Application No: FG/74/22/HH
Site Address: Sumara The Warren Ferring BN12 5PQ
Description of works: Front and rear dormer replacement. Replacement green roof and reinstatement of chimney and associated works. Removal of two rear conservatories and replace with terrace. Alterations to fenestration and render system to brick facades.

Thank you for your internet representation made on 30th June 2022 which has been recorded as an objection with the comments as follows:

Proposed Ground Floor Plan

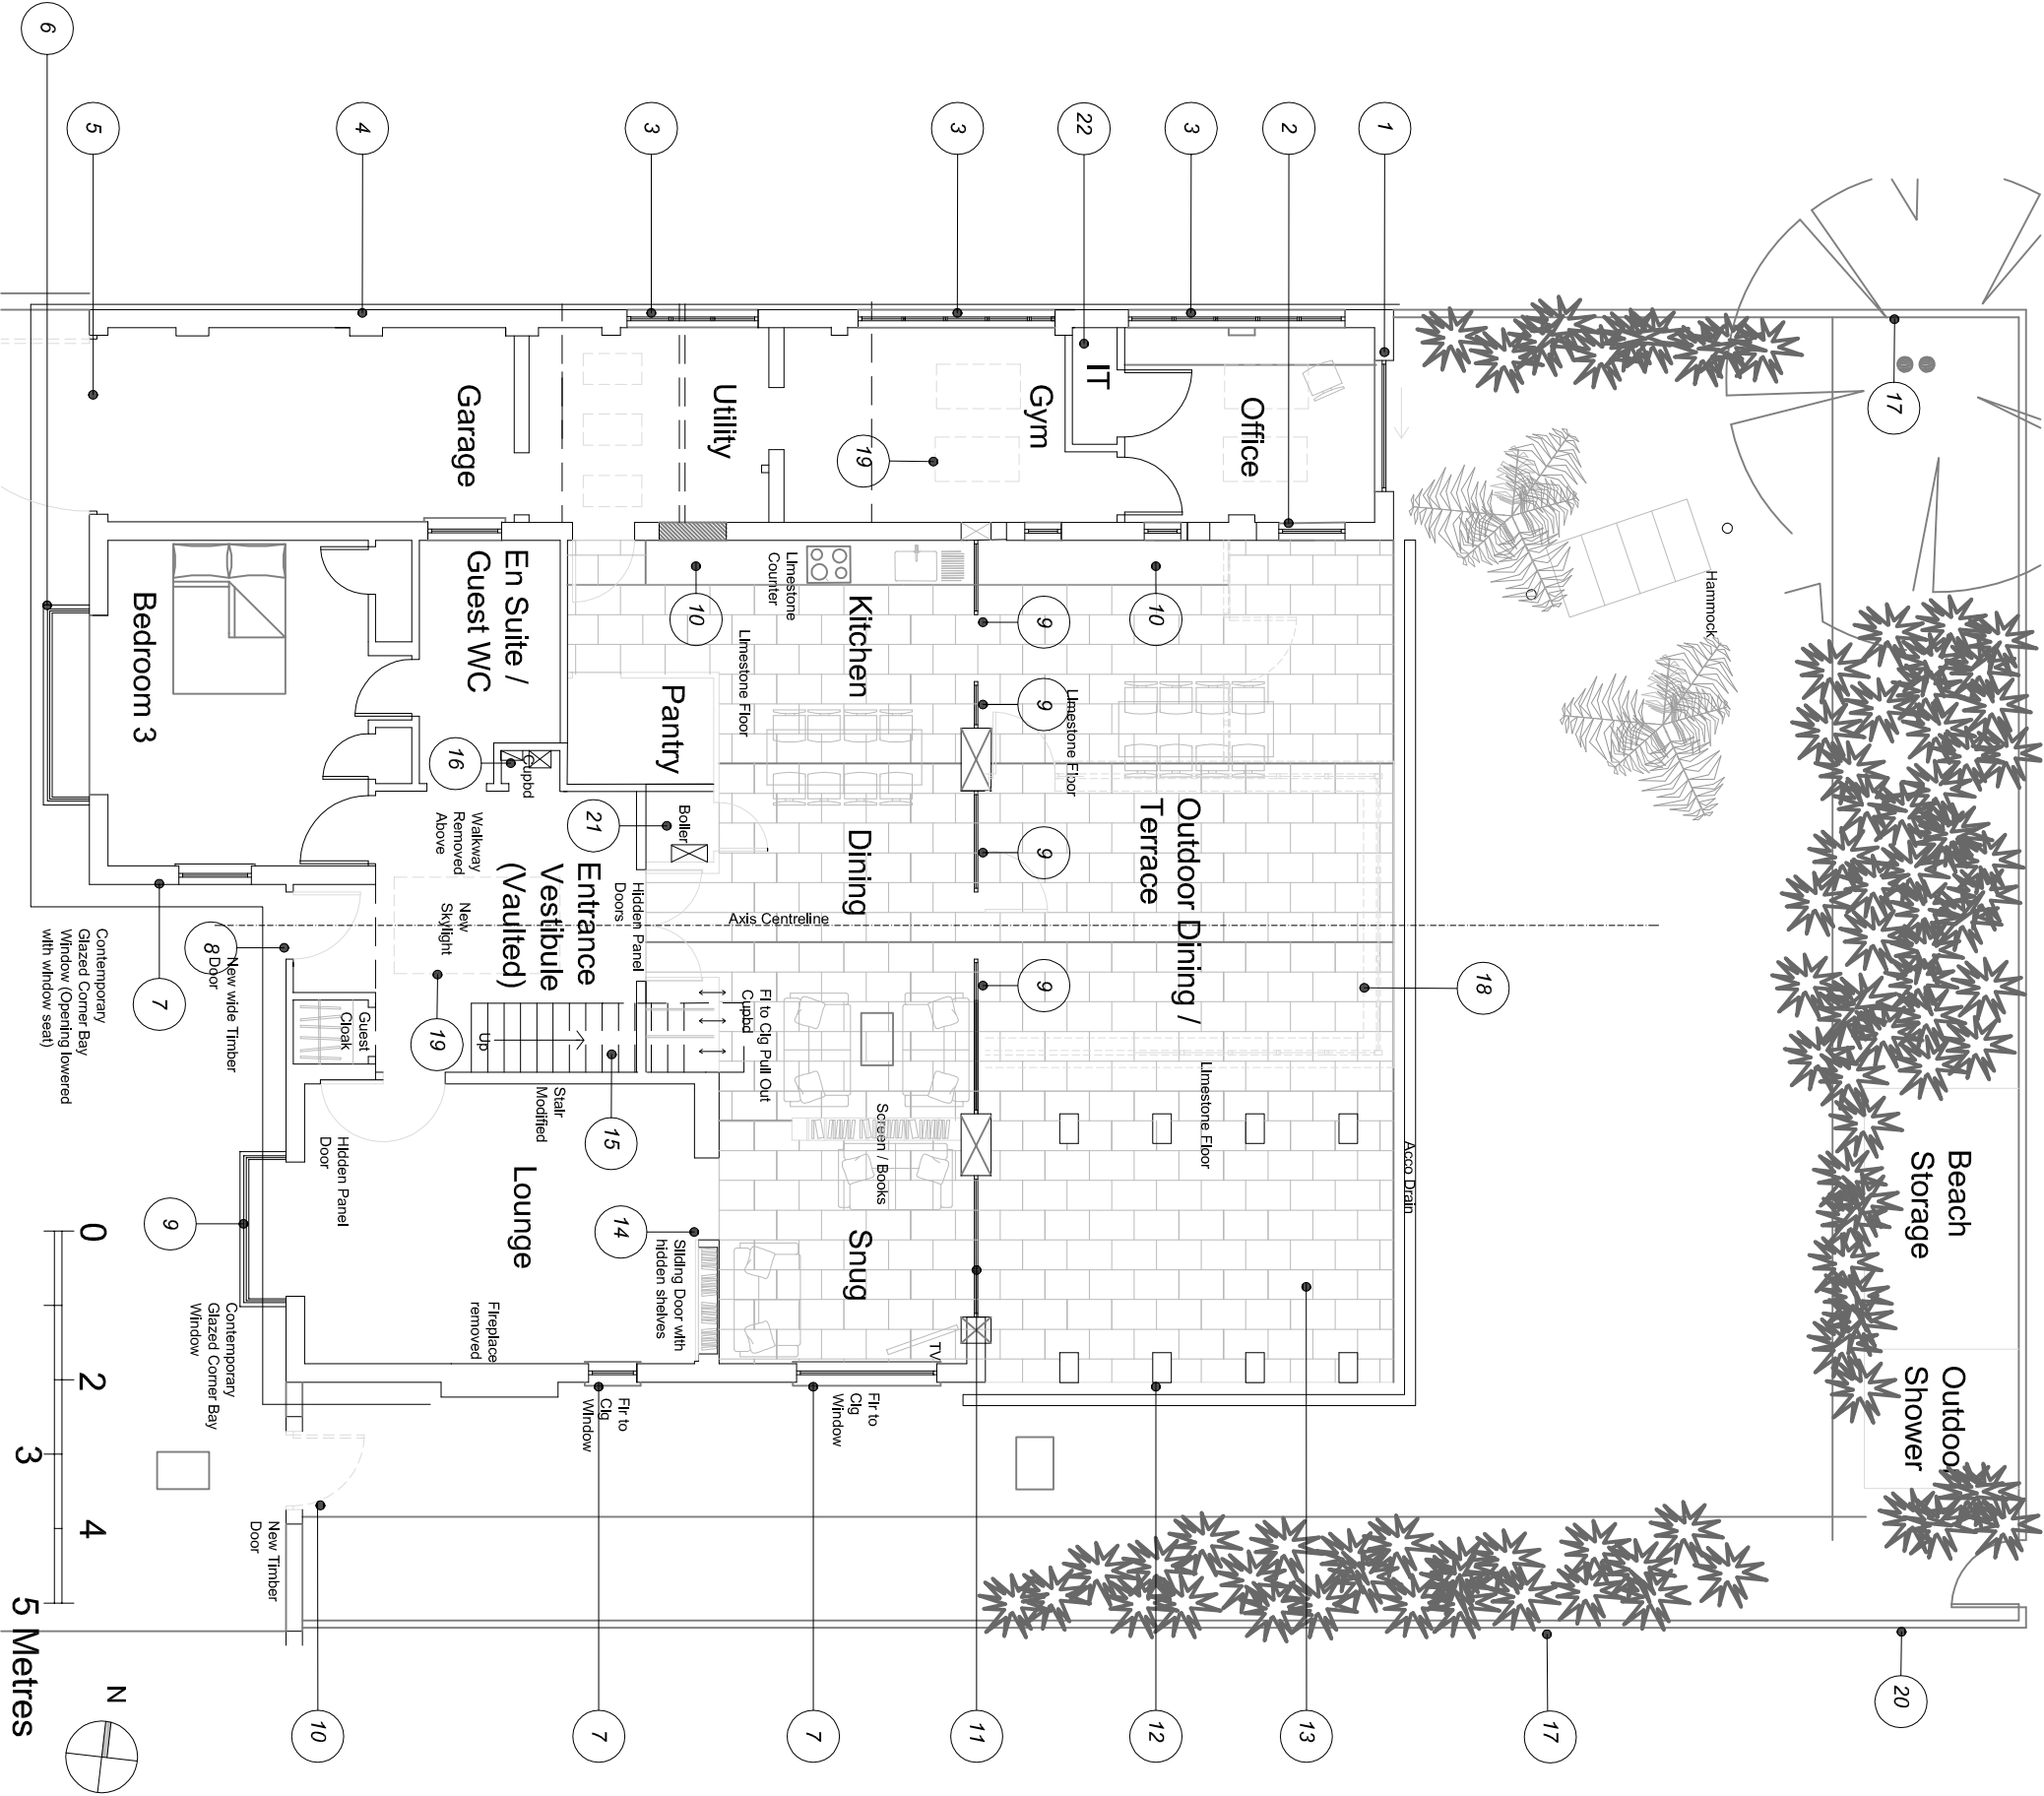
In looking at the plans, it appears that there are proposed new double glazed opaque windows close to, or on, the boundary with the adjacent property. While we are not affected directly, we are concerned that such windows directly overlooking the adjoining property, even though opaque, could affect the privacy of that property and, if approved, sets a dangerous precedent for our district.
